# PLANNING BOARD REPORT PORTLAND, MAINE

Pleasant Avenue Church Redevelopment  
3, 15, and 16 Pleasant Avenue  
Level III Site Plan and Subdivision Review  
2015-102  
Peninsula Property Development

Submitted to: Portland Planning Board Date: November 5, 2015 Public Hearing Date: November 10, 2015	Prepared by: Nell Donaldson, Planner CBLs: 130-H-13, 130-I-12, 130-I-14 Project #: 2015-102
---	---

**SOUTH & EAST  
ELEVATIONS**

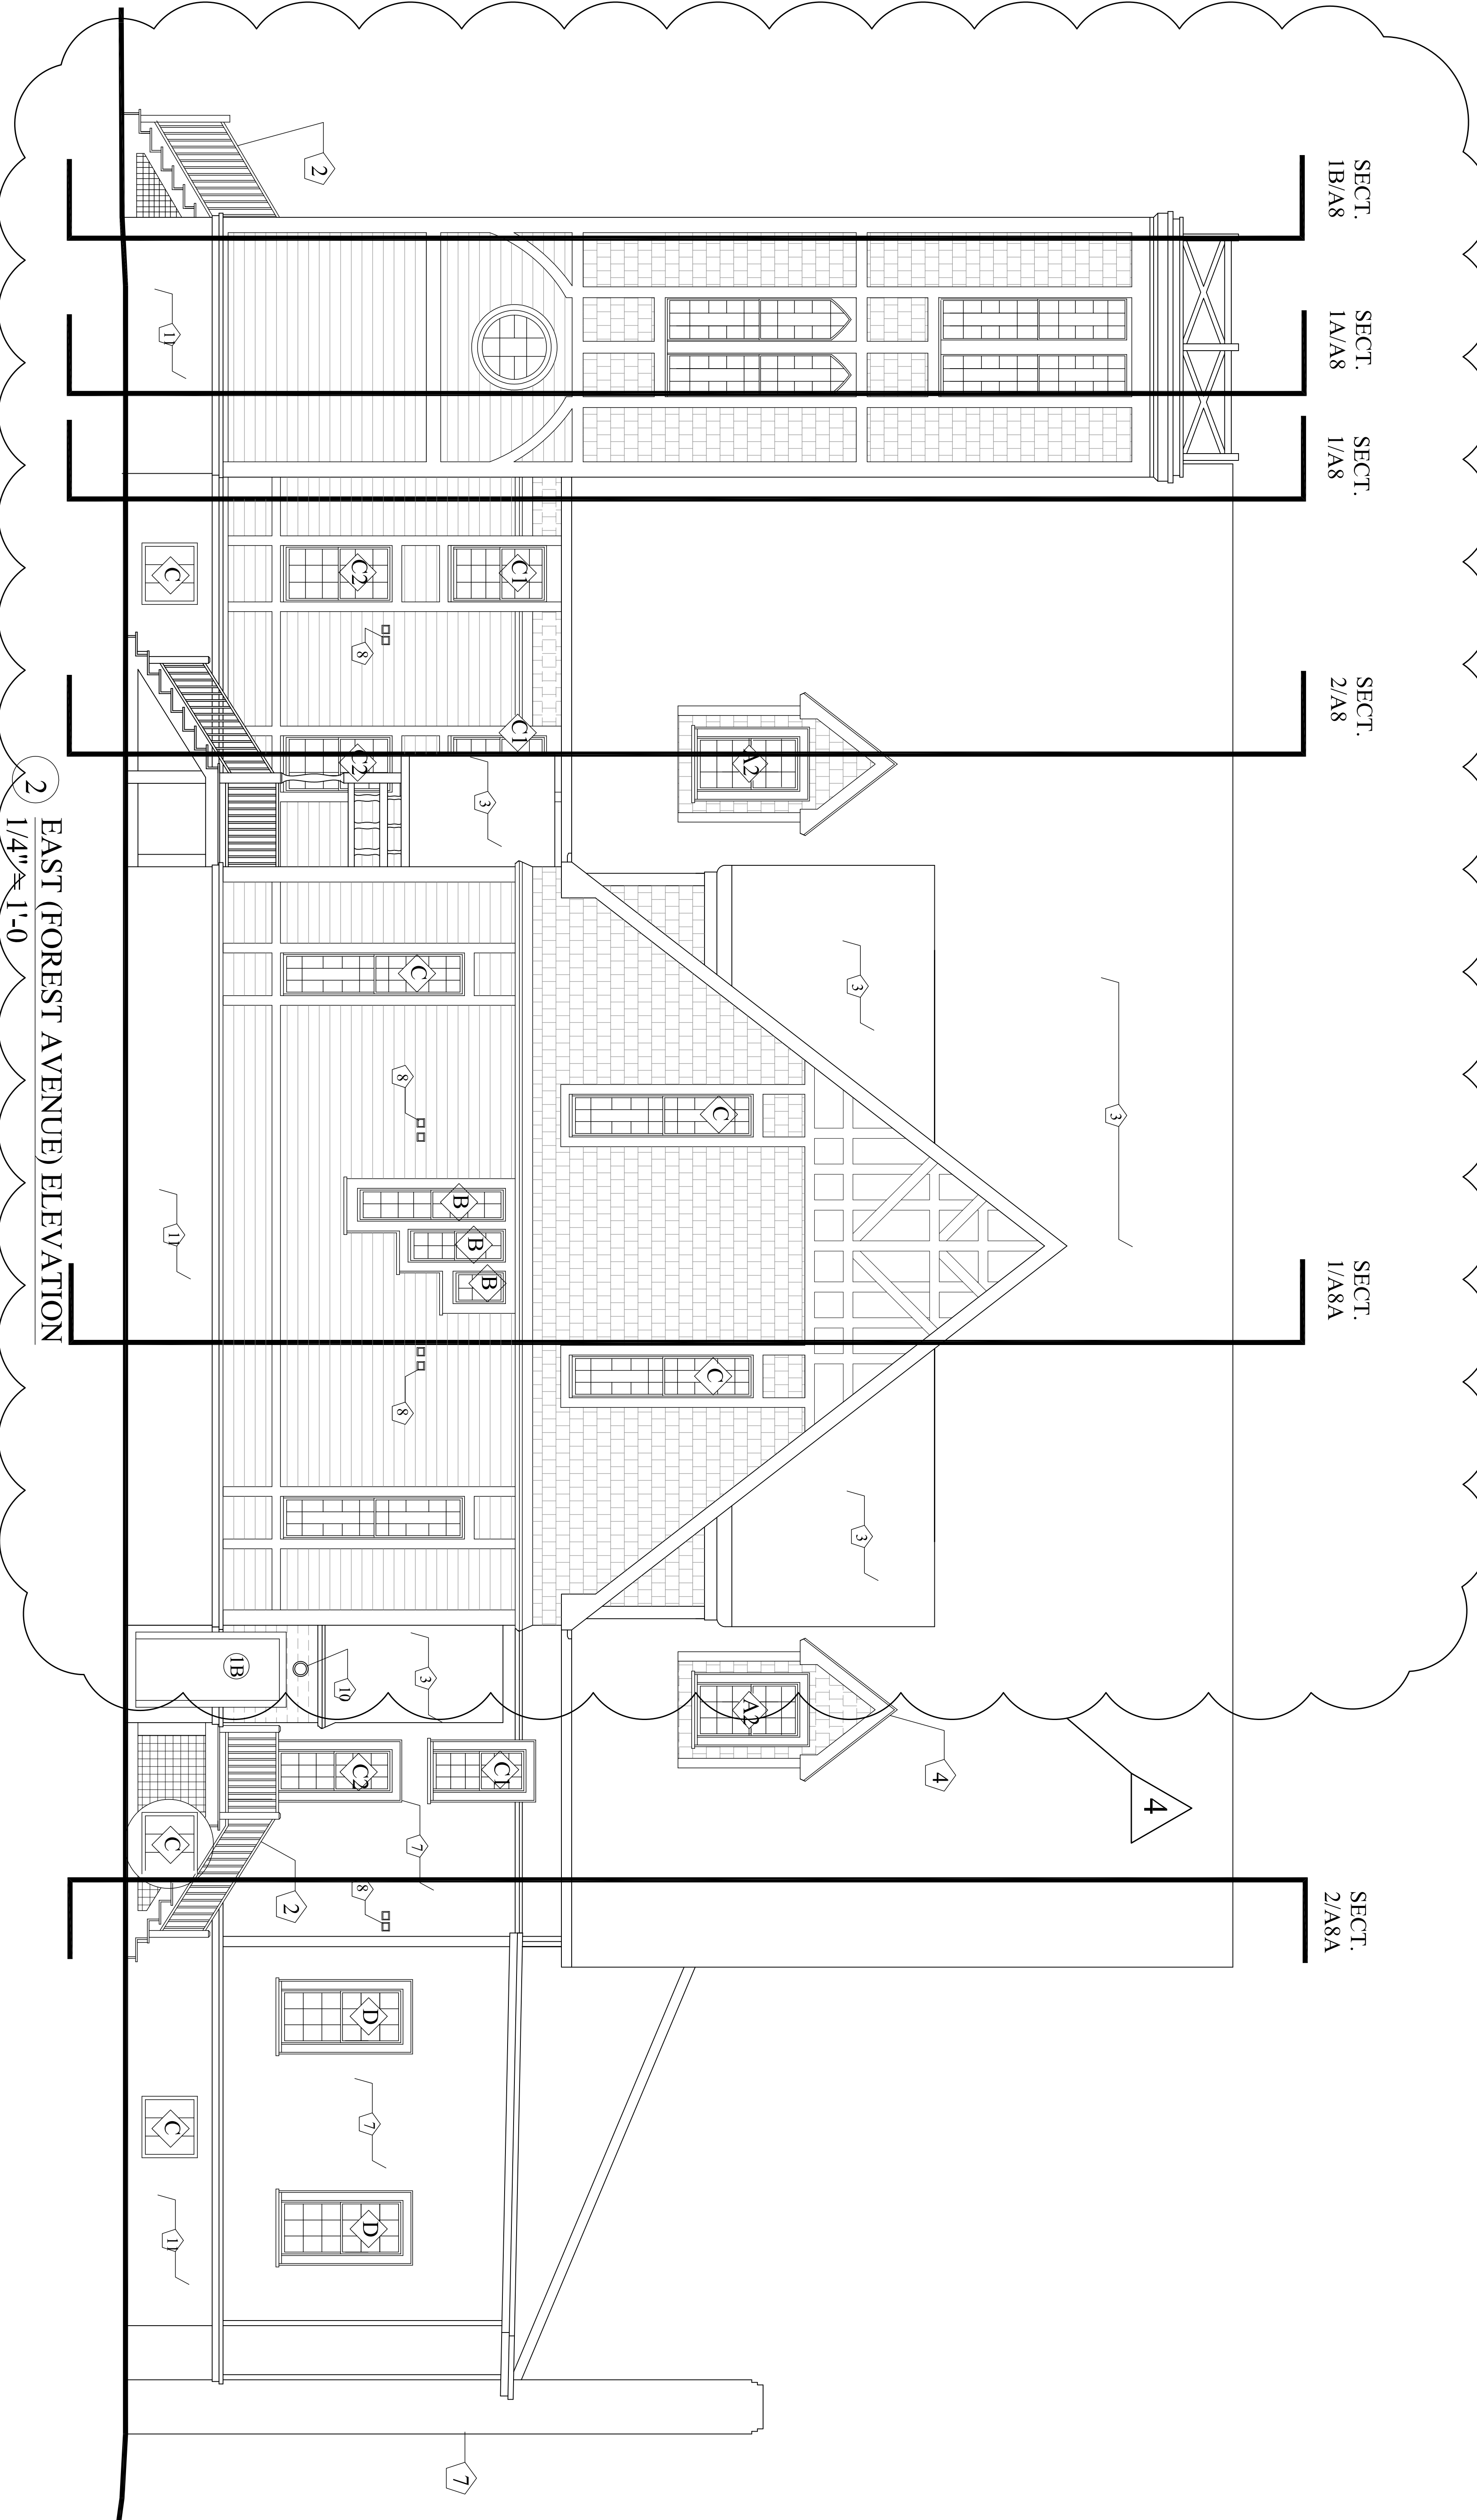
The applicant has not proposed any changes to the existing rectory building. However, they have proposed modest exterior changes to the existing church building, including the addition of doors, windows, and several dormers. These additions have generally been designed to integrate with the building's existing

historic character. Based on the multi-family design standards, the city's urban designer has requested that the applicant:

- Review the elevations, particularly with respect to the north side, to ensure that the drawings accurately depict the existing roof design and window pattern;
- Align proposed windows on the second and third floors on the north side with existing first floor windows; and
- Confirm that proposed dormers match the existing roof pitch.

At the time of final plan review, no additional drawings had been provided. The resolution of the design comments has been included as a condition of approval.

PROJECT PLEASANT AVENUE CHURCH RE-DEVELOPMENT			DRAWN: PBF DESIGNED: ADJ CHECKED: ADJ FILE NAME: SP-M167-SP
SHEET TITLE SITE LAYOUT PLAN			
CLIENT HARDY POND DEVELOPMENT COMPANY, LLC		P.E. ANDREW D. JOHNSTON LIC. # 9394	SHEET C-3.0
1 06.17.15 PRELIMINARY CITY SUBMISSION	REVISIONS

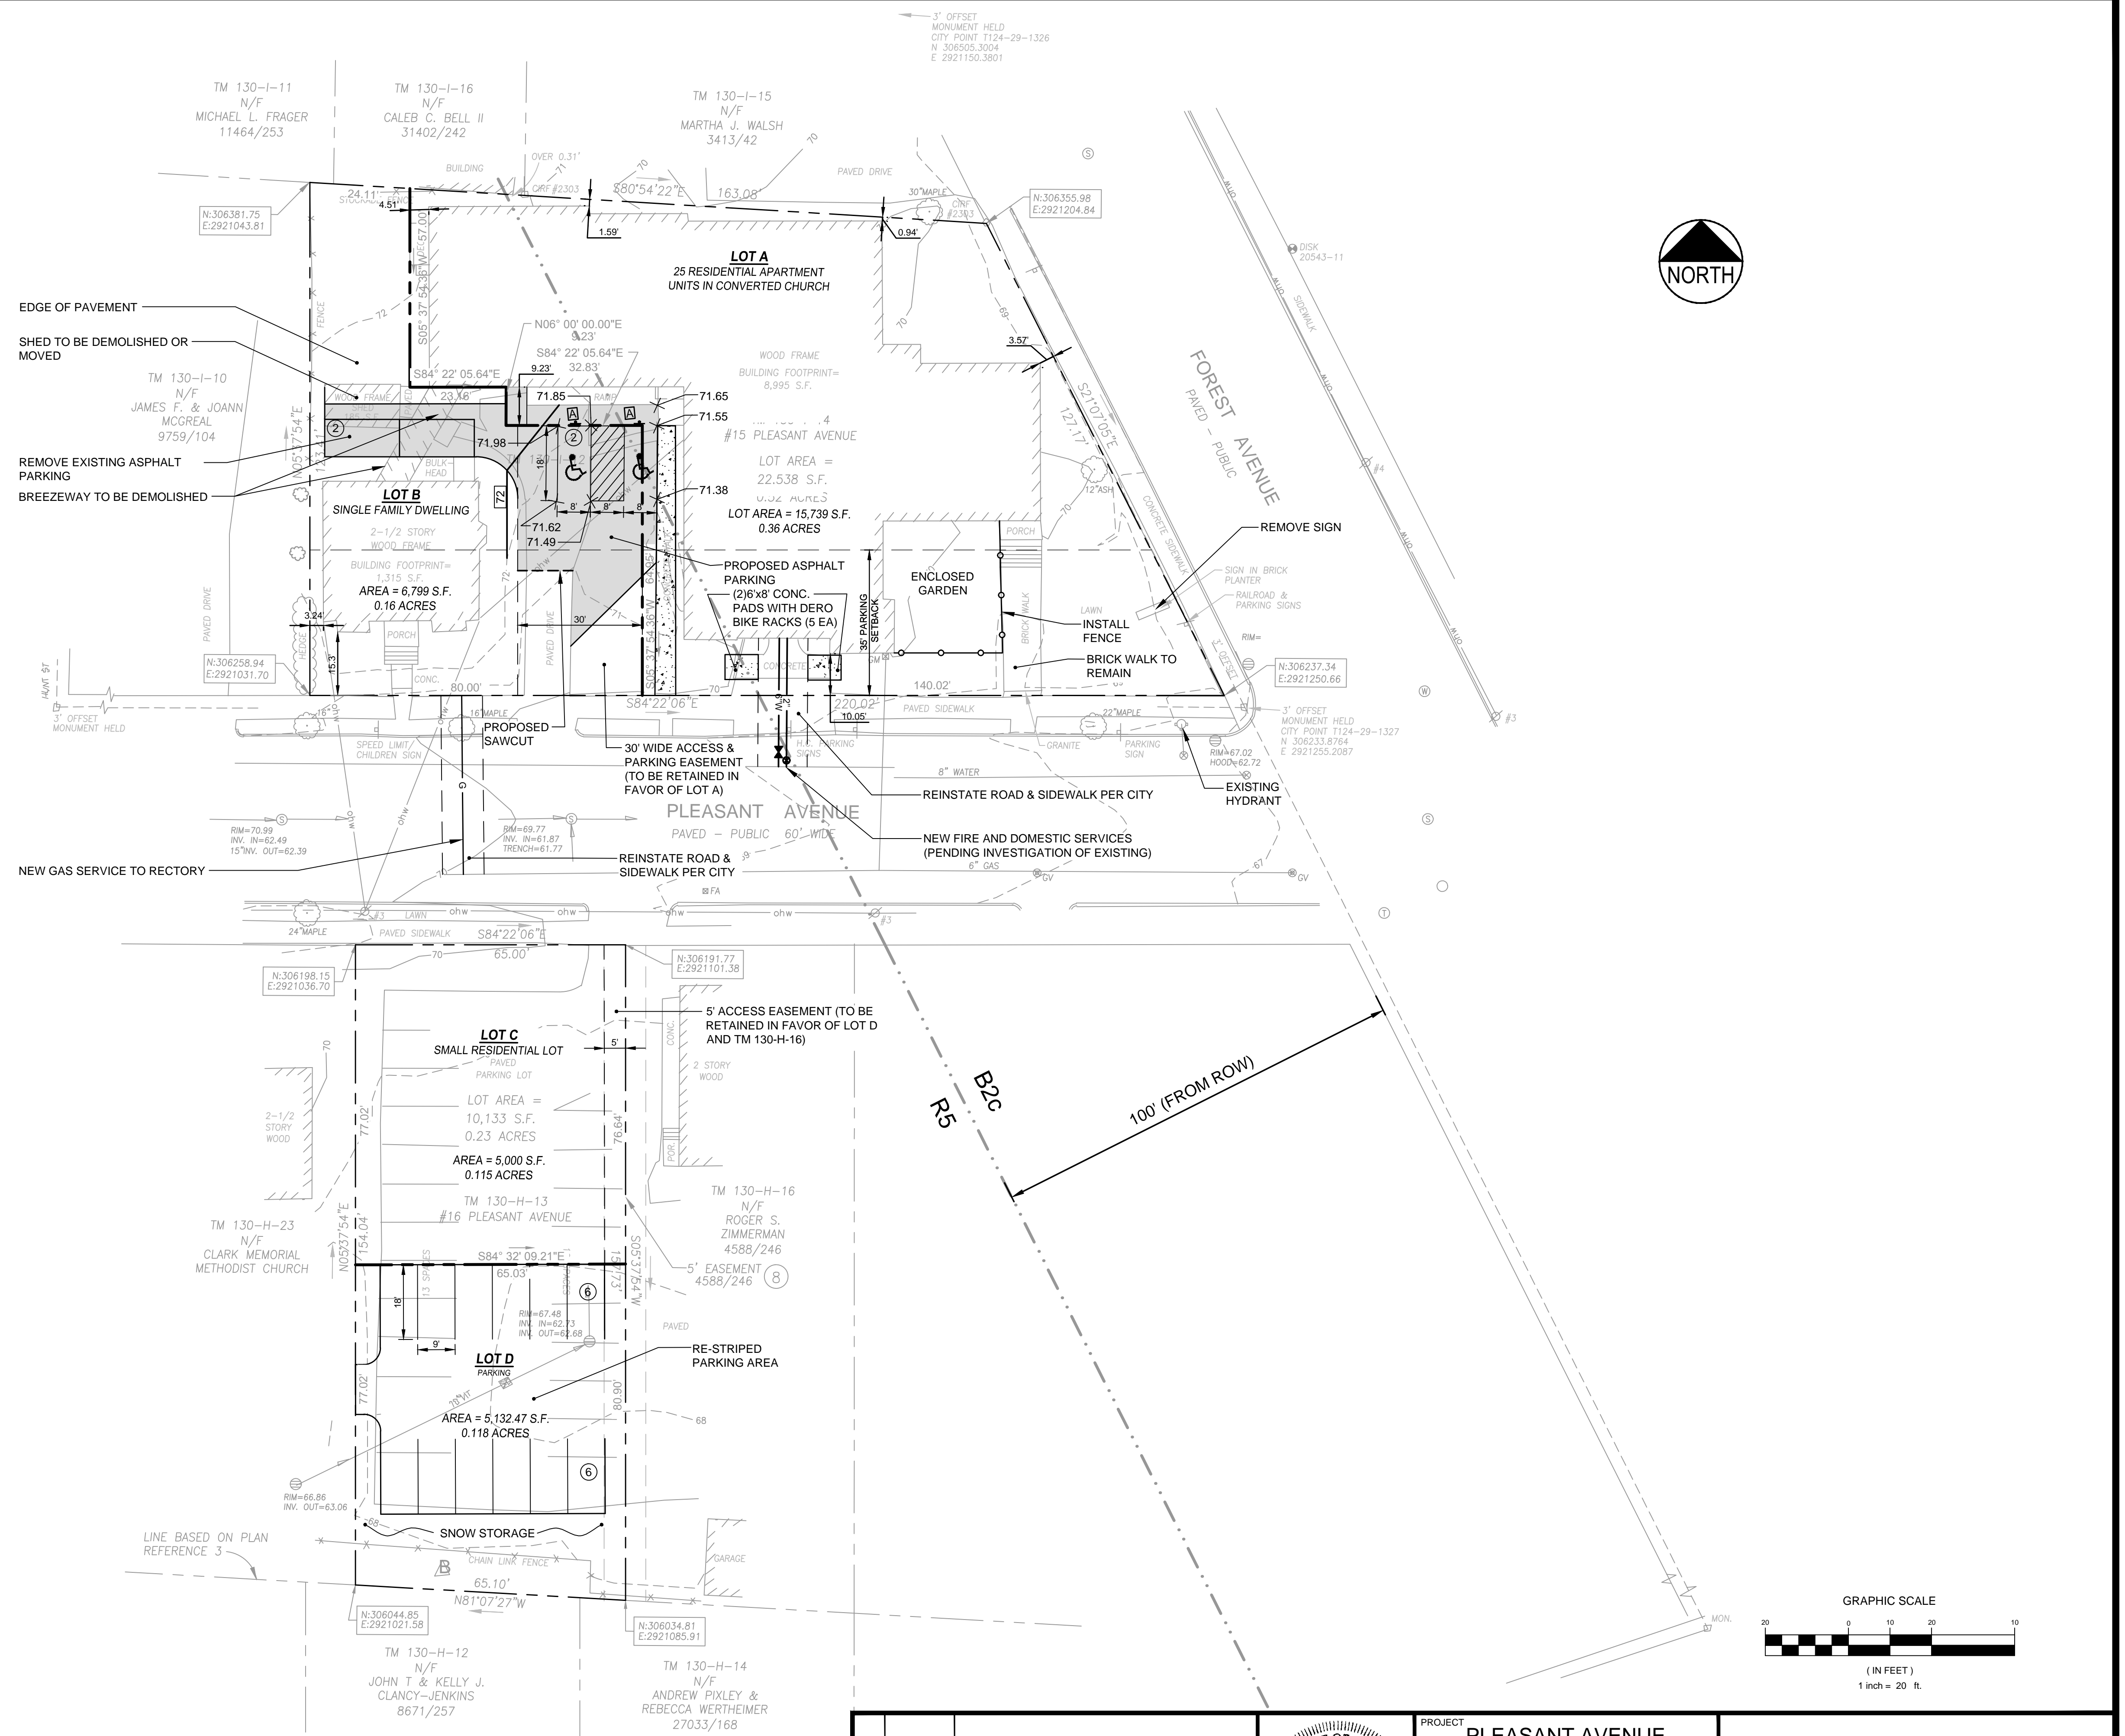
During the board workshop on this proposal, staff discussed the potential to either redesign or move the southernmost ADA parking space on the 15 Pleasant Avenue lot to meet the intent of the active street frontage provisions, although compliance is not technically required given that the parking on the plan falls in the R-5 zone and not the B-2c. In their revised submittal, the applicant has reiterated the difficulty of redesigning these spaces, as well as a preference for retaining the ADA spaces in close proximity to the accessible building entrance. The spaces have not been relocated.

The applicant has proposed to provide vehicular access to ADA parking serving the church lot at 3 Pleasant Avenue and parking serving the single-family home at 15 Pleasant Avenue via the existing curb cut on the north side of Pleasant Avenue. This driveway, as well as the ADA parking for the church redevelopment, will technically lie on the single-family lot at 15 Pleasant Avenue, with a 30 foot wide access easement to the church property.

In the revised submittal, the applicant provided turning templates in an effort to document that circulation can occur to the parking for the single-family home at rear, but Mr. Errico indicated that his concerns remained. Ultimately, the applicant and Mr. Errico agreed that stacked parking represents the preferred design option for the single-family parking, and the applicant revised plans to that effect. Mr. Errico has indicated that he has no further comments on the parking circulation (*Attachment 1*).

Given that this project is over 20 residential units and located along a transit route, a transit facility, consisting of a transit shelter and a pullout bay, is technically required. Following conversations with METRO, the applicant has identified a transit shelter pad on the plans. The applicant has depicted a public access easement surrounding the shelter site on the draft subdivision plan. It appears that a pullout is not possible given right-of-way constraints. Additional coordination with METRO will be required to identify the exact location of the transit facilities. Plans showing the final location and details related to this shelter have been included as a condition of approval.

Division 20 of the land use ordinance requires one parking space per unit for residential development in the B-2 zone (*Section 14-332(a)*). At this ratio, the church redevelopment would be required to provide 25 parking spaces for the 25 residential units. The final plans show 23 parking spaces off-site at 16 Pleasant Avenue and two ADA spaces next door at 15 Pleasant Avenue, or exactly 25 spaces. Both of these parking areas lie within 100 feet of the church lot at 3 Pleasant Avenue, thus meeting the requirements of *Section 14-334* of the ordinance, which permits off-site parking for uses in non-residential zones. In the final submittal, the applicant has adjusted the striping adjacent to the handicapped parking spaces to ensure that it meets the requirements for a van accessible space.

The final plans show a transformer on the Forest Avenue frontage at the northeast corner of the property. Staff has discussed the location of the proposed transformer on the Forest Avenue frontage with DPS, Mr. Tarling, and the applicant in an effort to find a more discreet location. There is some potential that the transformer might be moved to a nearby pole; otherwise, evergreen landscaping or fencing will be required per the site plan ordinance. The resolution of this issue has been included as a condition of approval.
